FW: Tudor Close Public House Ferringham Lane Ferring BN12 5NQ - FG/86/21/DOC

Planning Application reference: FG/86/21/DOC

Proposal: Approval of details reserved by condition imposed under ref FG/105/20/PL relating to Condition Nos 3 - car parking, 4 - materials & finishes, 5 - covered & secure cycle parking spaces, 6 - Arboricultural Impact Assessment, 8 - decentralised, renewable & low carbon energy and 9 - charging of electric vehicles.

Address: Tudor Close Public House Ferringham Lane Ferring BN12 5NQ

R.1 - Parking & Charging Arrangement

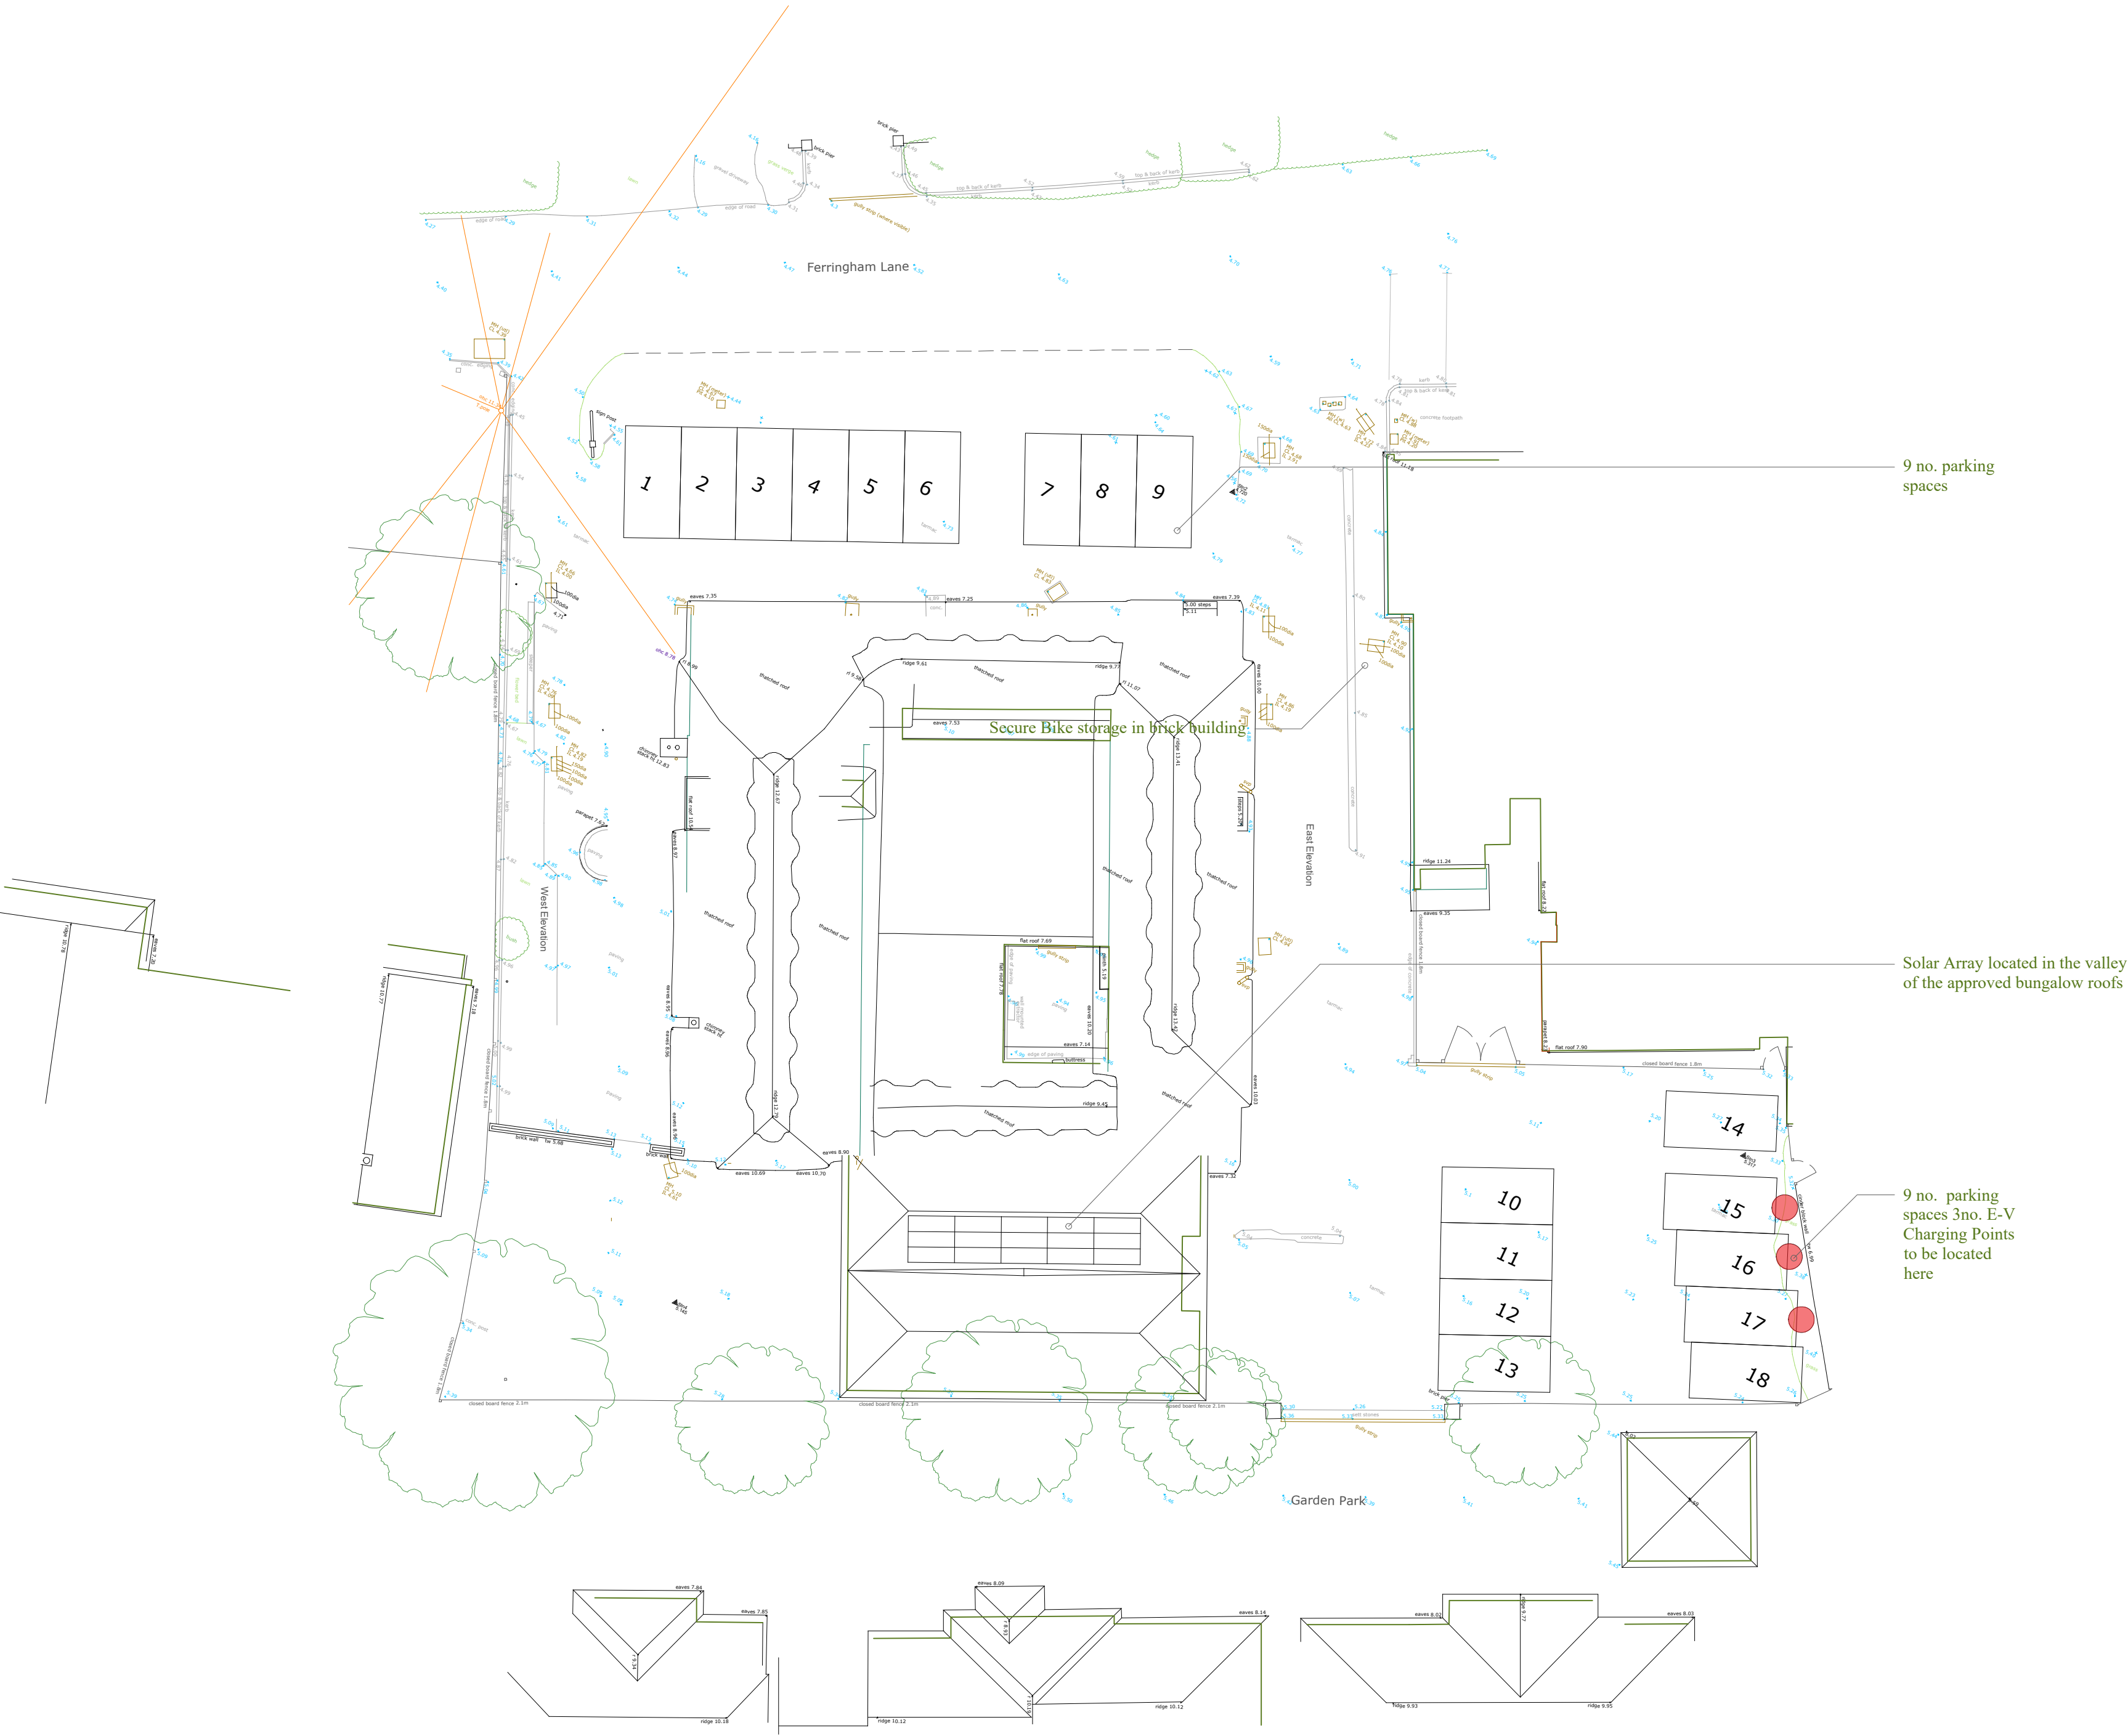
I can confirm that the proposed EV charging point is included in the governments EVHS approved charge point model list. However, the HM Government document entitled 'Electric Vehicle Charging in Residential and Non-Residential Buildings' requires that an EV charging point is installed in every dedicated car parking space when new dwellings are constructed.

The applicant has proposed to install 3 EVCP's and proposes 9 new residential dwelling units. I therefore request that the applicant install 1No. electric vehicle charging point for each dwelling, or demonstrate / justify that this is not technically feasible due to lack of infrastructure from the national grid at the proposed development site
